Ribble Valley Borough Council
Council Offices
Church Walk,
Clitheroe
Lancashire
BB7 2RA

Phone: 0300 123 6780
Email: developeras@lancashire.gov.uk
Your ref: 3/2025/0647
Our ref: 3/2025/0647/HDC/KW
Date: 16 October 2025

Location: Clitheroe Football Club Shawbridge Street Clitheroe BB7 1LZ
Proposal: Proposed demolition of existing clubhouse and construction of new clubhouse and community hub.
Grid Ref: 374720 441735

Client: Clitheroe Football Club Ltd.		
Project: Proposed New Clubhouse & Community Hub Shawbridge Pendle Road Clitheroe		
Dwg title: Proposed Site Plan		
Scale @ A3: 1:500	Date: 04.08.25	Drawn by: PD
Drawing no. 1720 - 102	Rev. -

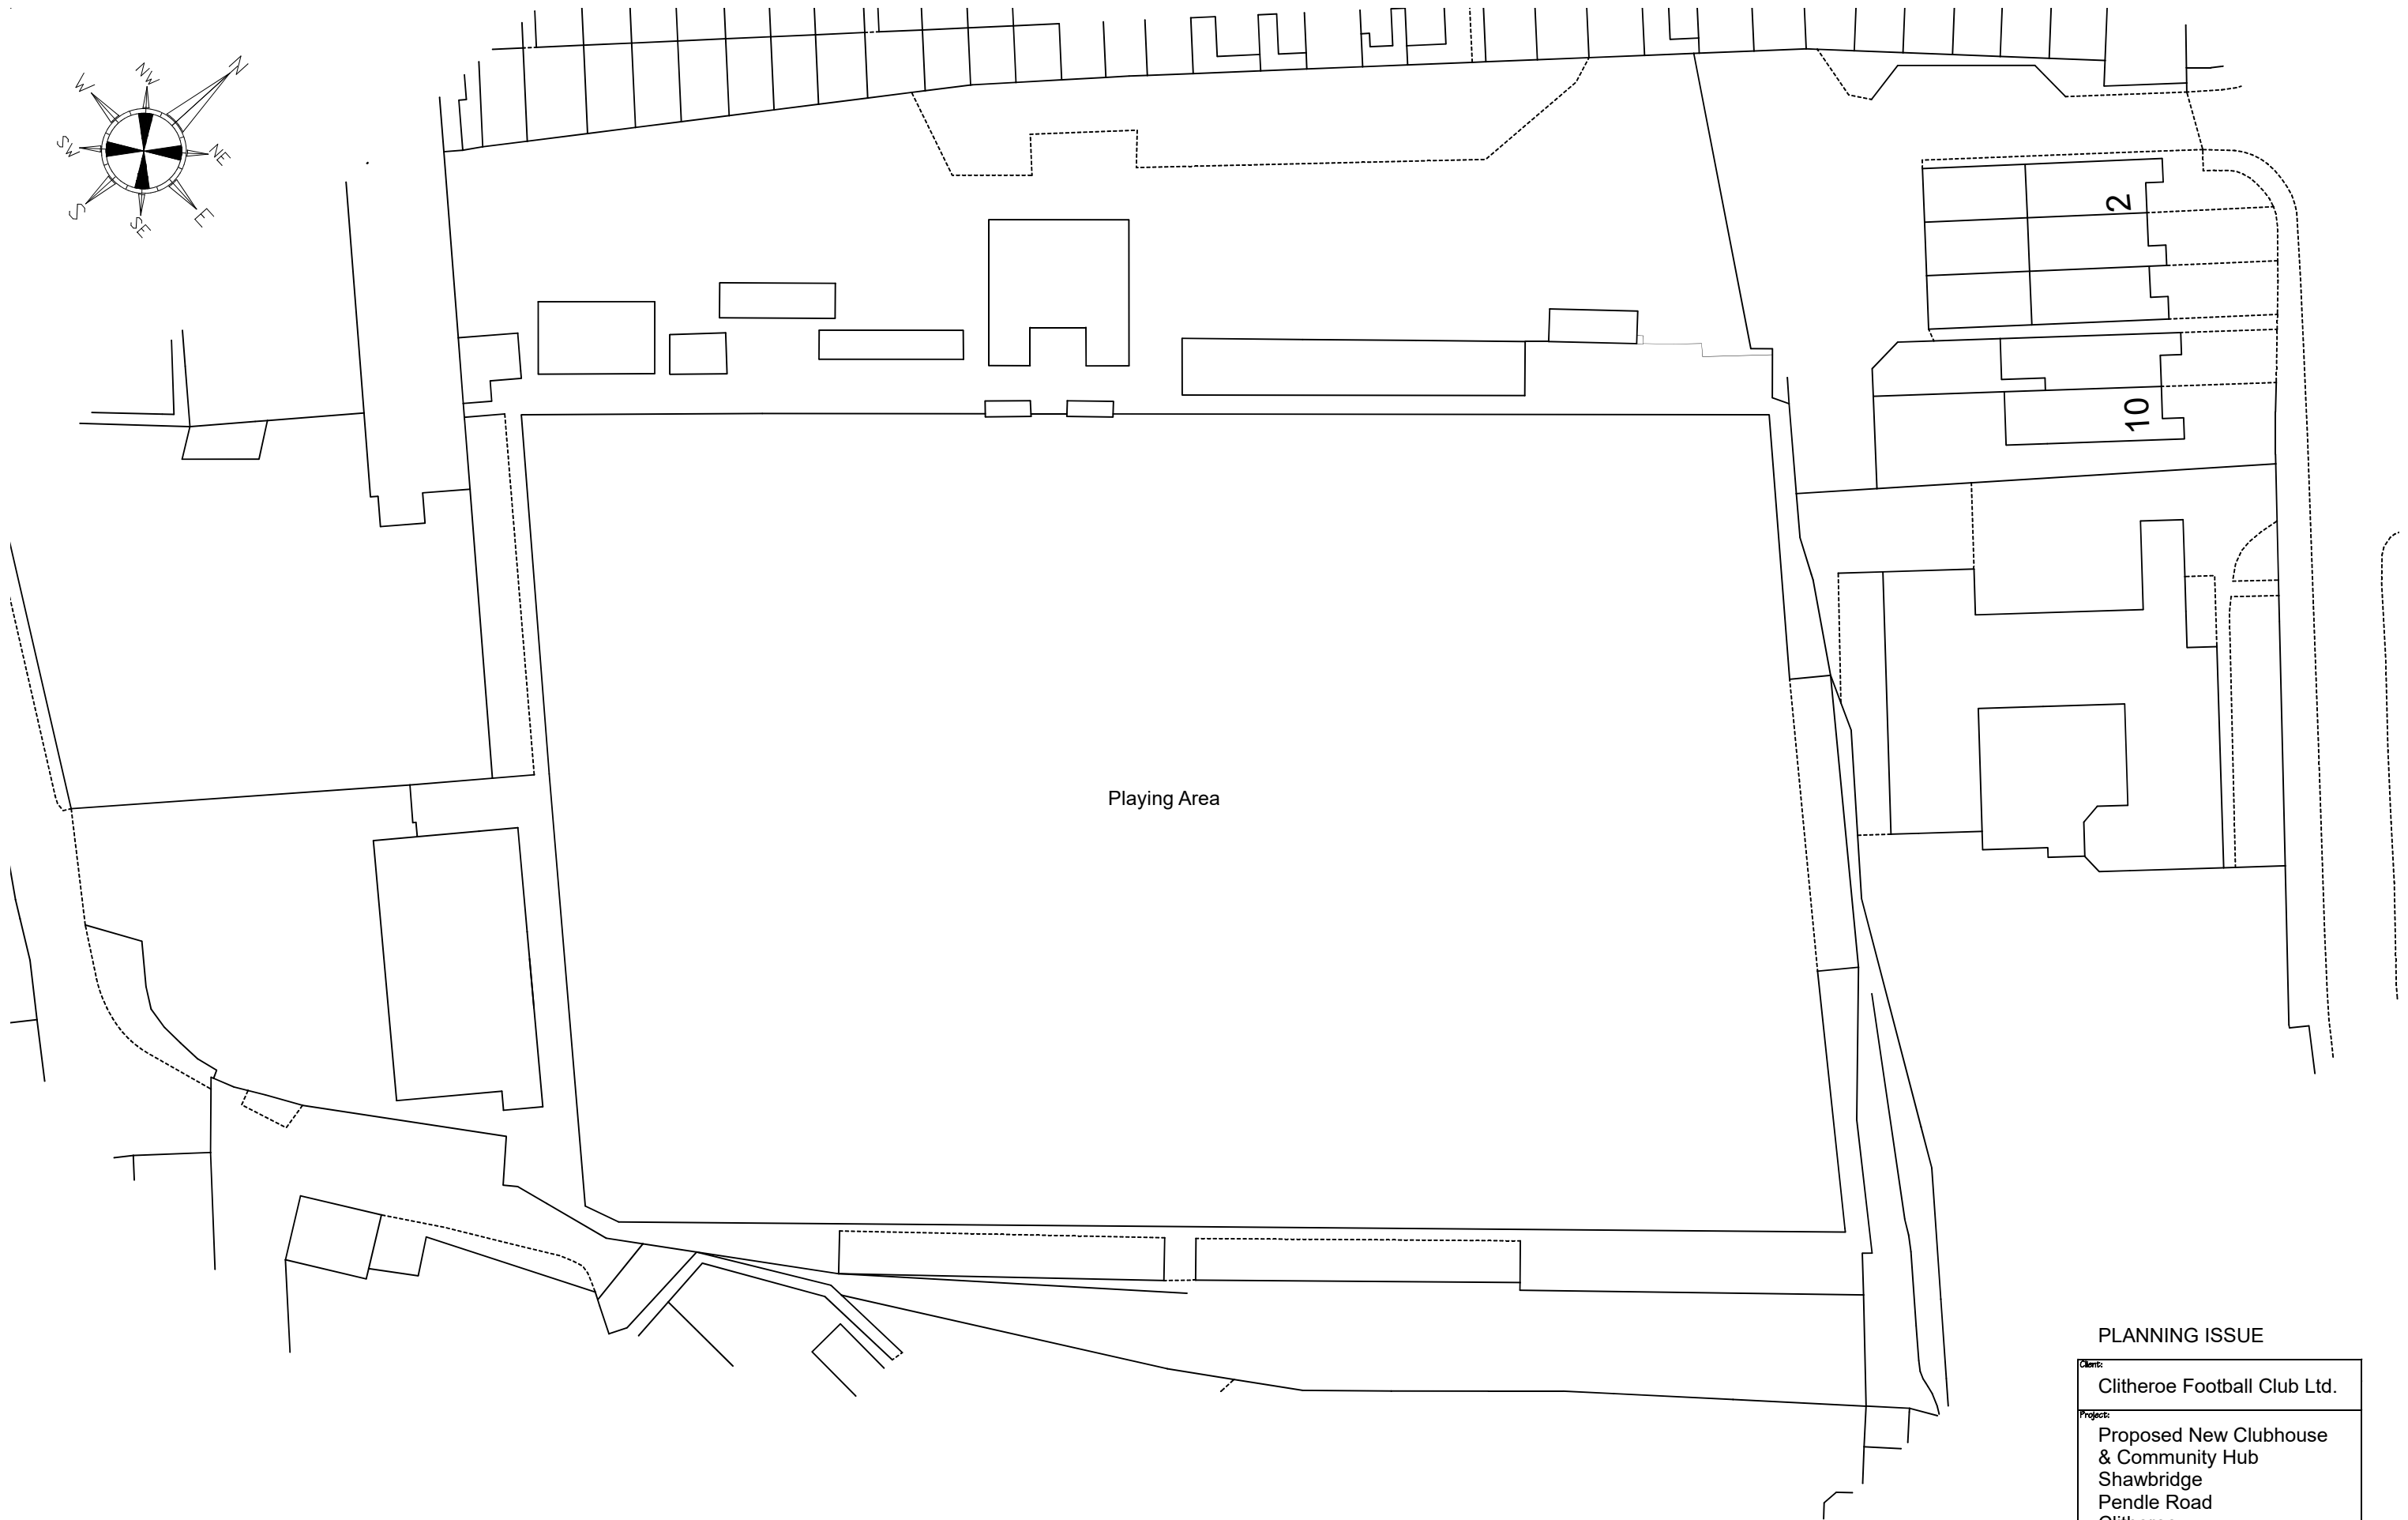
The LHA have reviewed drawing number 1720 - 102 titled "Proposed Site Plan" and are aware that the site accesses, on Bright Street and Shawbridge Street, will remain unaltered following the proposal. Therefore, the LHA have no further comments to make regarding the access.
